MECKLENBURG COUNTY
Land Use & Environmental Services Agency

MEMORANDUM

To: Charlotte-Mecklenburg Planning Commission
From: LUESA, Mecklenburg County
Date: 3.27.24
Subject: Rezoning Petition Comments

2024-027: Walmart 1666 OGP Expansion

REZONING SITE PLAN

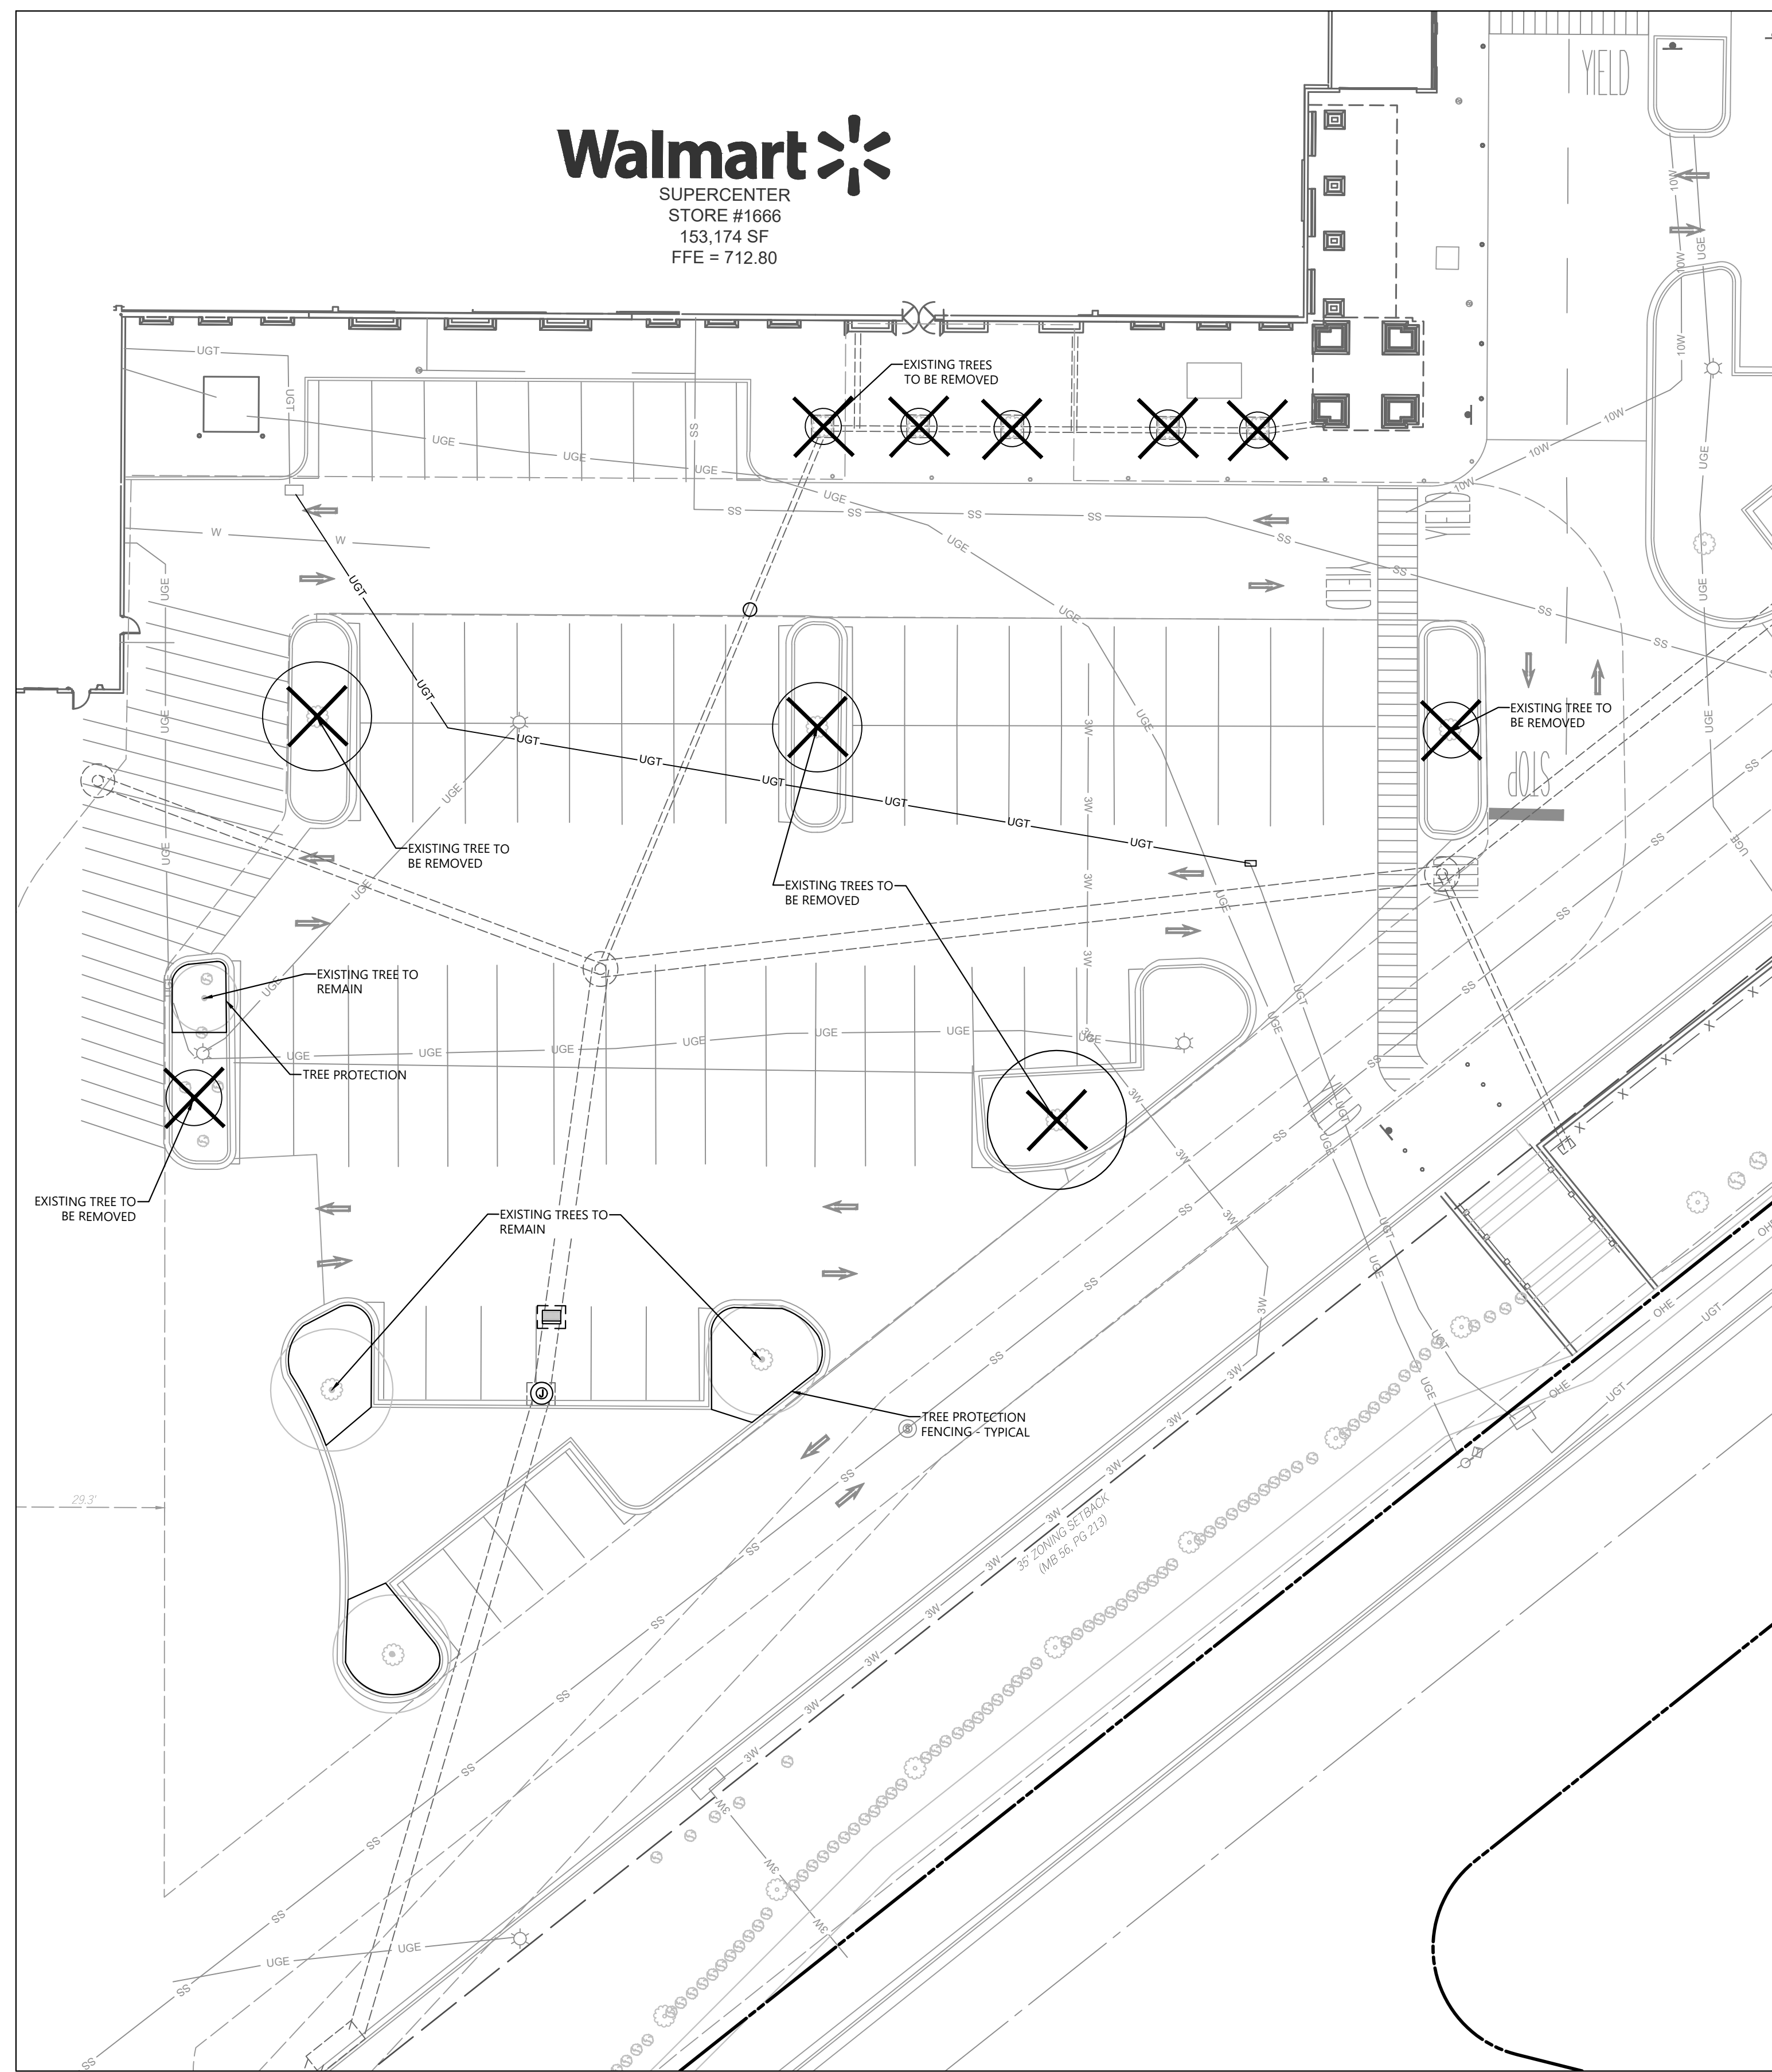
Groundwater & Wastewater Services records indicate a Subsurface Investigation Permit (SIP) was issued for parcel 161-027-11. Please note that monitoring wells on this parcel need to be located, flagged and protected prior to development or be permanently abandoned in accordance with the Mecklenburg County Groundwater Well Regulations.
